Item No. **Report of the Head of Development Management and Building Control**

Address: 13 CHESTNUT CLOSE HAYES

Development: Erection of single storey rear extension following demolition of extension.

LBH Ref Nos: 78553/APP/2024/283

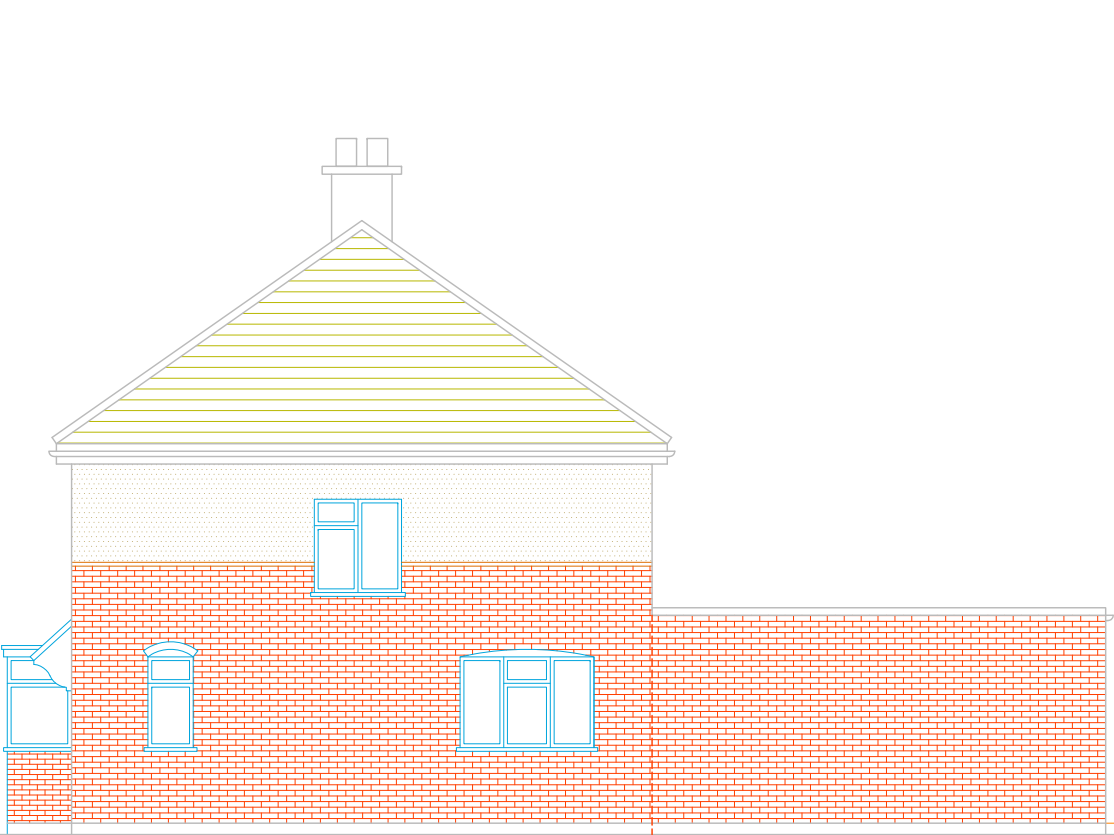
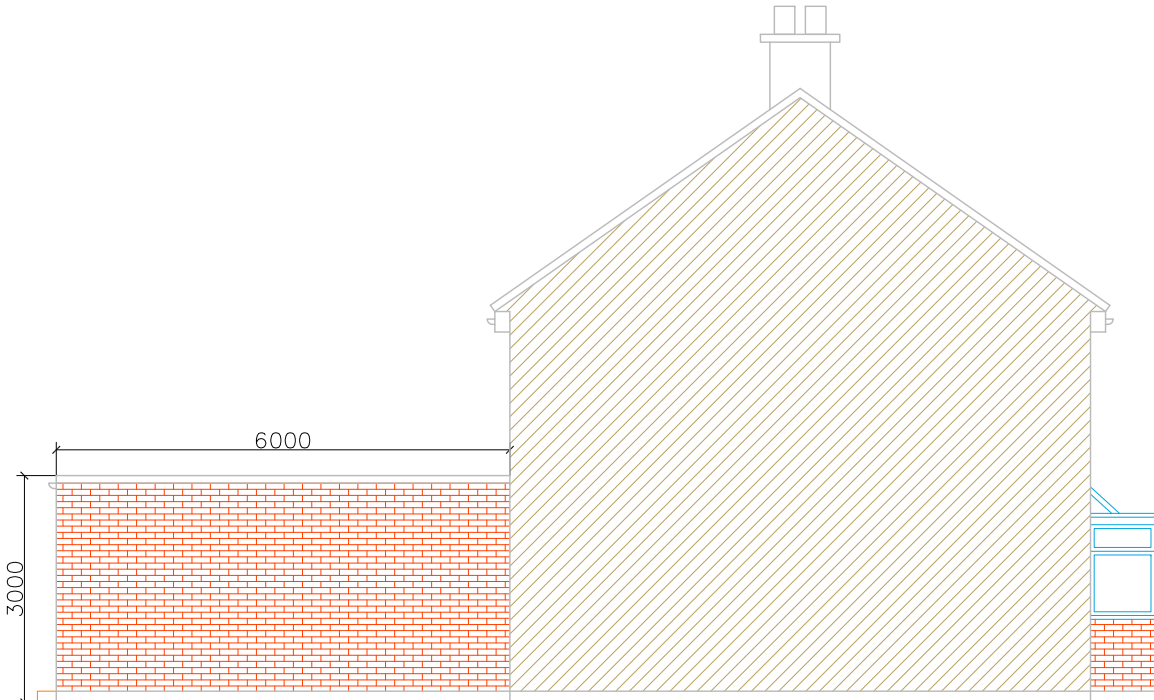
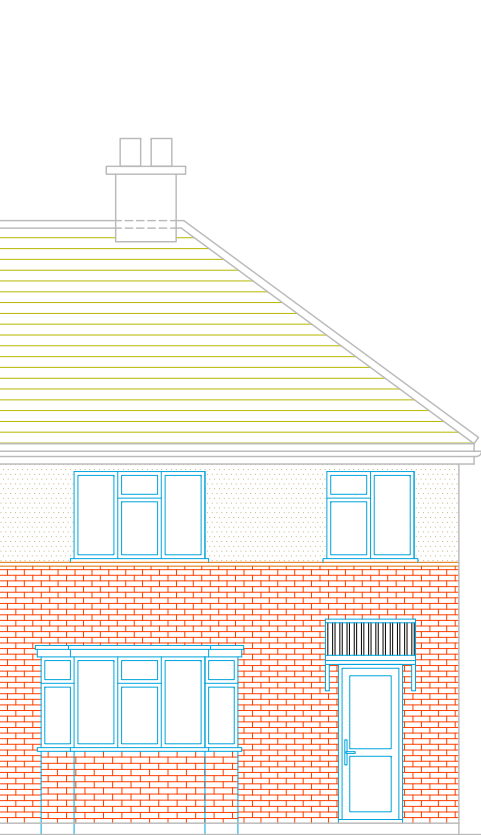
The application proposes a single storey rear extension which would measure a depth of 6m, a length of 5.4m and will feature a gently sloping flat roof measuring a maximum height of 3m. Policy DMHD 1 requires single storey rear extensions on semi-detached properties to not exceed 3.6m in depth. The proposed 6m deep rear extension would almost double the footprint of the original property creating a disproportionate and over dominant addition to the dwelling. By virtue of the overall scale and depth of the rear extension, it is considered that the proposal would cause harm to the character and appearance of the original property.

The proposed ground floor rear extension, by reason of its excessive depth, design and bulk would appear as a disproportionate and incongruous addition that would fail to respect the architectural composition or size of the original dwelling. The extension is therefore considered to be detrimental to the character, appearance and visual amenities of the host property. Due to its oversized design it would also be harmful to character of the surrounding area where extensions are generally smaller. The proposal would therefore be contrary to Policy BE1 of the Hillingdon Local Plan: Part One - Strategic Policies (November 2012) and Policies DMHB 11, DMHB 12 and DMHD 1 of the Hillingdon Local Plan: Part Two - Development Management Policies (January 2020), Policy D3 of the London Plan (2021) and paragraph 139 of the NPPF (2023).
